City of Albuquerque Stormwater Construction Site Inspection Report

ESC File No.	H17E097	Project Name:	Carlisle Crossing		
NPDES Id. No.	NMR10040K NMR10040H	Location:	2100 Carlisle Blvd. NE		
3/16/2023	Owner	Contractor			
Operator	Carlisle Associates LP	Jaynes Corp.			
Contact name & title	Dave Rosen C/O Joe Bernabeo	Jesus Ortiz			
e-mail	jbernabeo@rosenmgmt	jesus.ortiz@jaynescorp.com			
Contact Phone #	505-304-4516	505-345-8591			
COA Inspector	Doug Hughes	Start/End Time:	1:30pm		
Construction Phase:	Parking lot done, no construction, landscaping and building incomplete.				
Type of Inspection:	Regular	Storm Event	Past Storm Event >0.25"	311/Complaint	Follow Up
Weather at time of inspection?		Cloudy	Temperature:	~	45
Estimated date of last storm 0.25" or greater		12/4/2022

CARLISLE CROSSING	
PROJECT TITLE	
ALBUQUERQUE, NM, BERNALILLO COUNTY	
CITY, COUNTY, STATE	
DATE	03/22/2023
DRAWN BY	B. Henriksen / J. Tolman
 INSPECTIONS PLUS

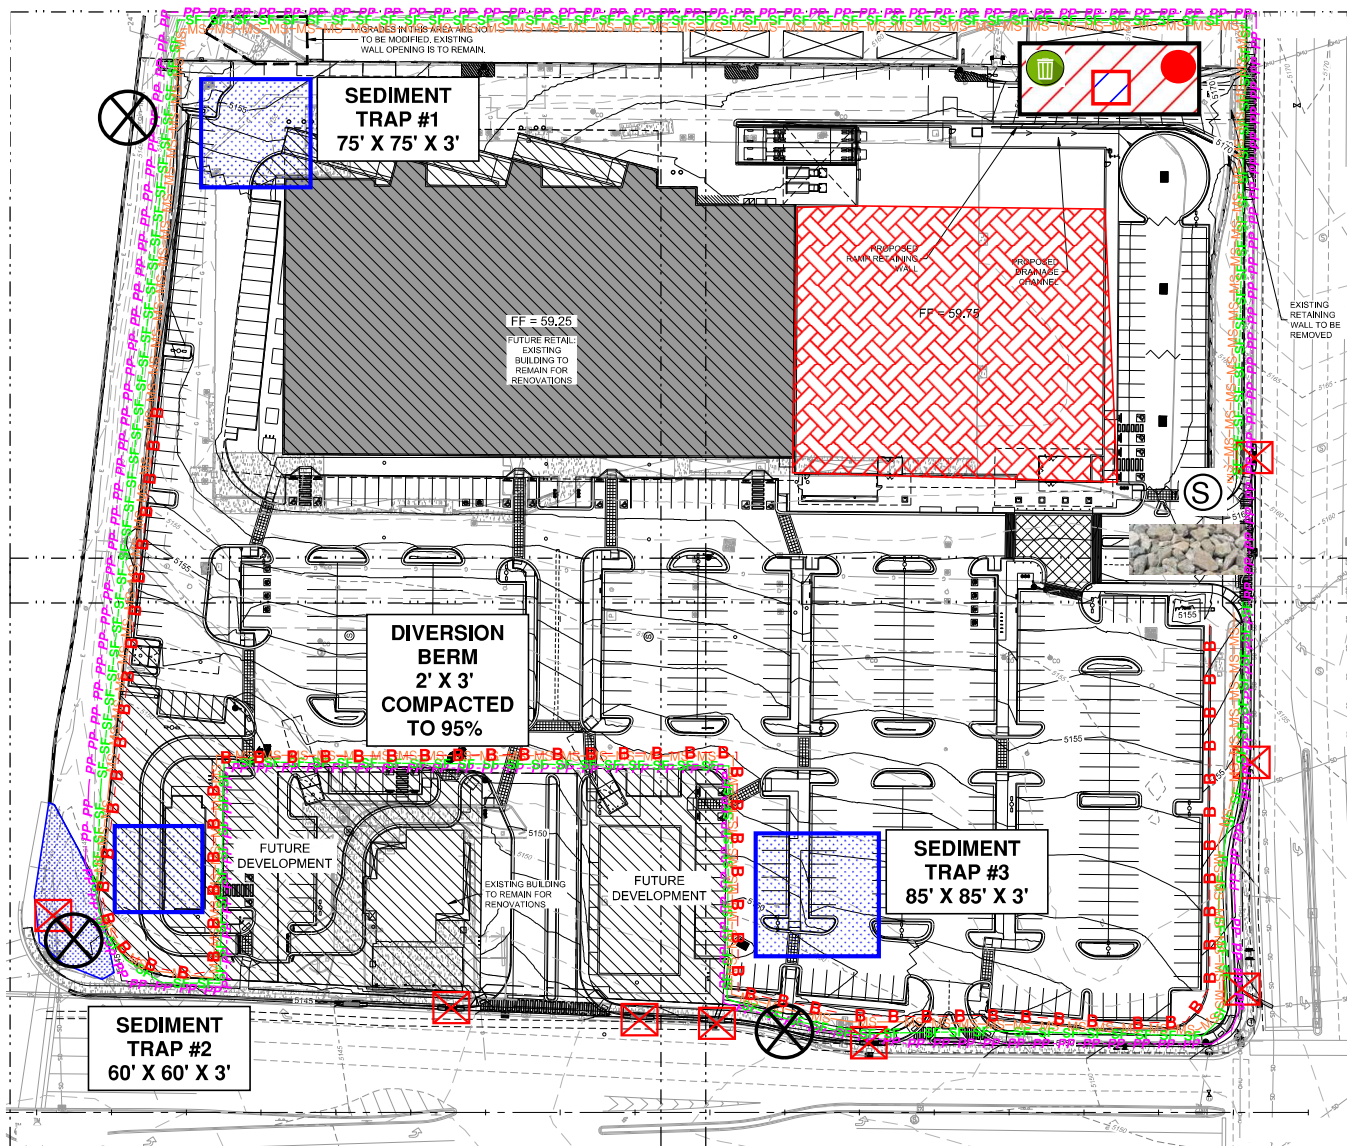
Item Number	Deficiency/ Corrective Action				
1	Property owners NOI expired. Provide NOI to the City for approval, along with modified ESC Plan (SWPPP map) that reflects current conditions.				
2	SWPPP wasn't available on site at time of inspection, so it couldn't be checked to see if it is up-to-date. - Provide a scanned copy of the up-to-date SWPPP with all reports to the Storm Water Quality Section at 600 2nd St NW suite 400 - Jhughes@cabq.gov - Per CGP 4.8.2				
3	Permit coverage wasn't posted. You must post a sign or other notice of your permit coverage at a safe, publicly accessible location in close proximity to the construction site. The notice must be located so it is visible from the public road that is nearest to the active part of the construction site, and it must use a font large enough to be readily viewed from a public right-of- way per CGP 1.5				
4	Loading docks next to east side of building, two Pad sites, and all landscaping are still disturbed and need to be stabilized. - You must continue permit coverage, self-inspections, SWPPP and BMP maintenance until the City determines that the Final Stabilization Criteria CGP2.2.14.c has been satisfied. Then you must remove the BMPs and send documentation of the Final Stabilization to the EPA with a Notice of Termination (NOT) per CGP 8.2 to end your coverage under the CGP. This step is independent of the Work Order. Please copy me with the documentation and the EPA's acceptance of the NOT at that time. In the meantime seed and Hydromulch are required per CGP 2.2.14.
